Tel: 01903 737756
Email: planning@arun.gov.uk
www.arun.gov.uk/planning
Please ask for: Mrs D Johnson
Email: daun.johnson@arun.gov.uk
Telephone: 01903 737762
Our Ref: WA/20/26/PL
Your Ref:
Date: 31st March 2026

Application for Planning Permission

Development: Siting of 6 No glamping pods with associated structures, access, car parking and landscaping (part retrospective). This application may affect the setting of a listed building and is in CIL Zone 3 (Zero Rated) as other development.

Location: Land To The South Of The Black Horse Pub Binsted Farm Binsted Lane BN18 0LP

Drawing Title: PROPOSED ARRANGEMENT
Drawing Number: 148_02
Date: February 2025
Scale: 1:500 / 1:100 @A1

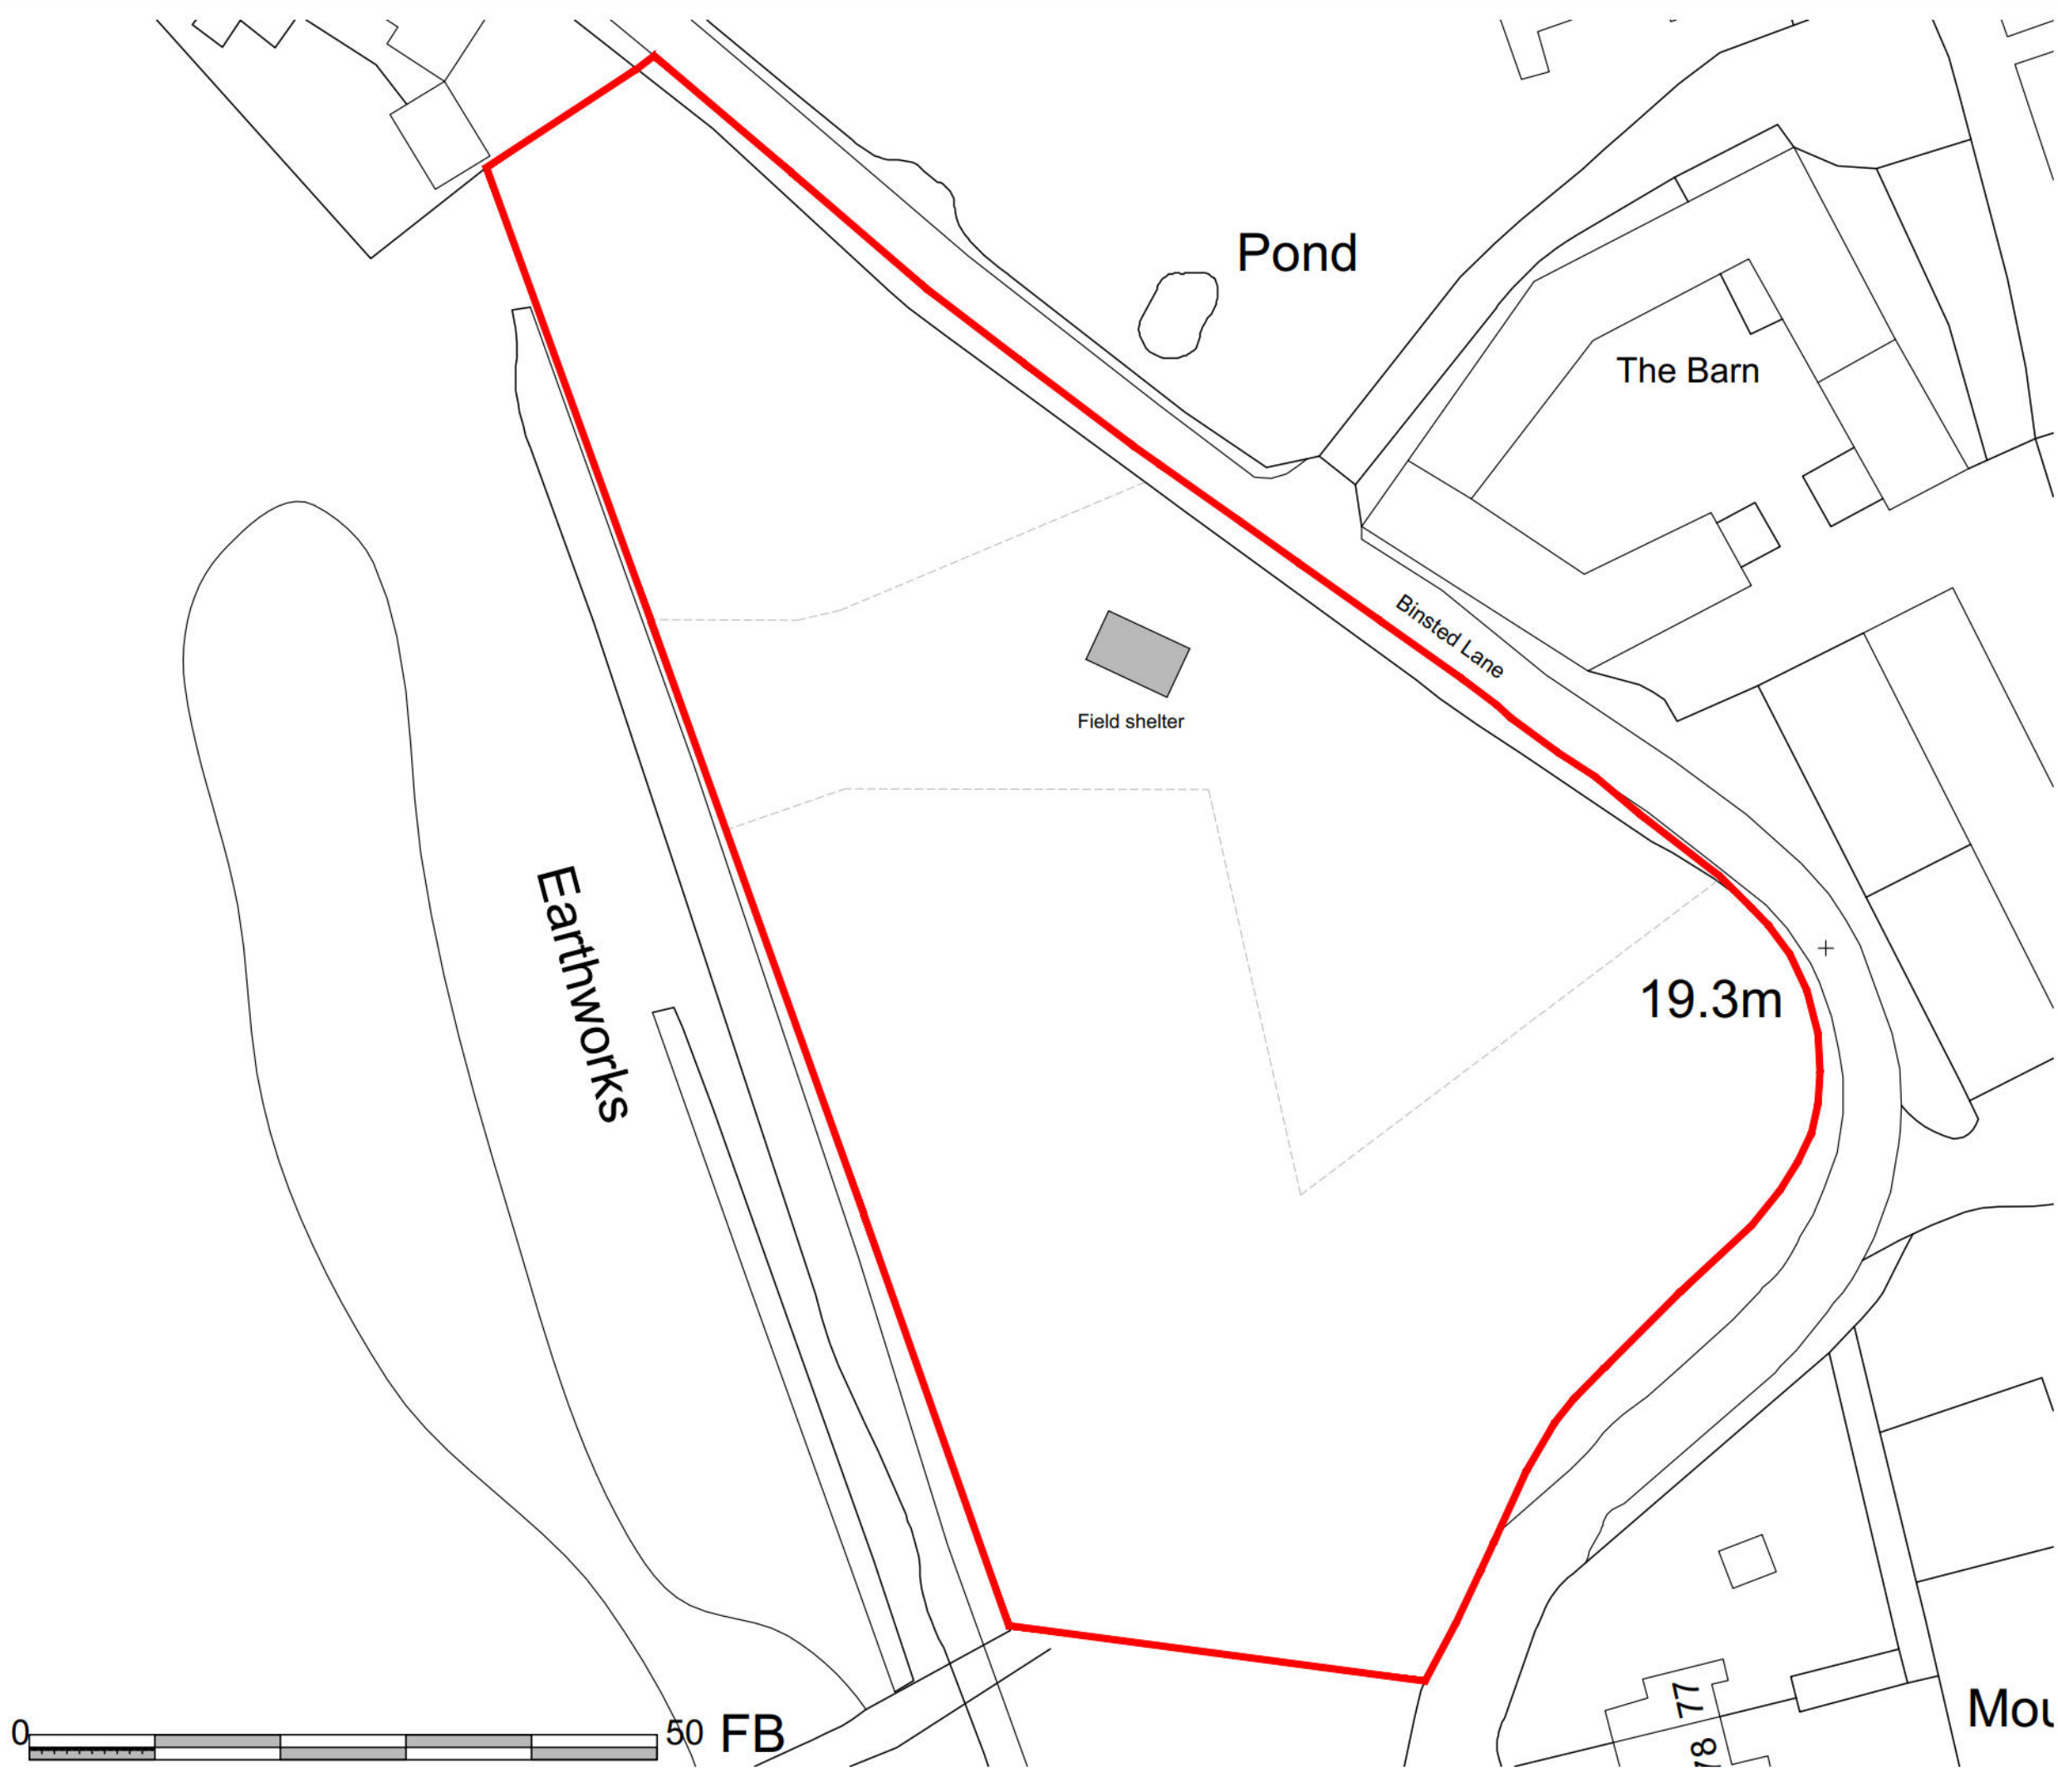
On the proposed arrangement plan, please show the position of all CCTV cameras, saunas, woodstore and outside showers.
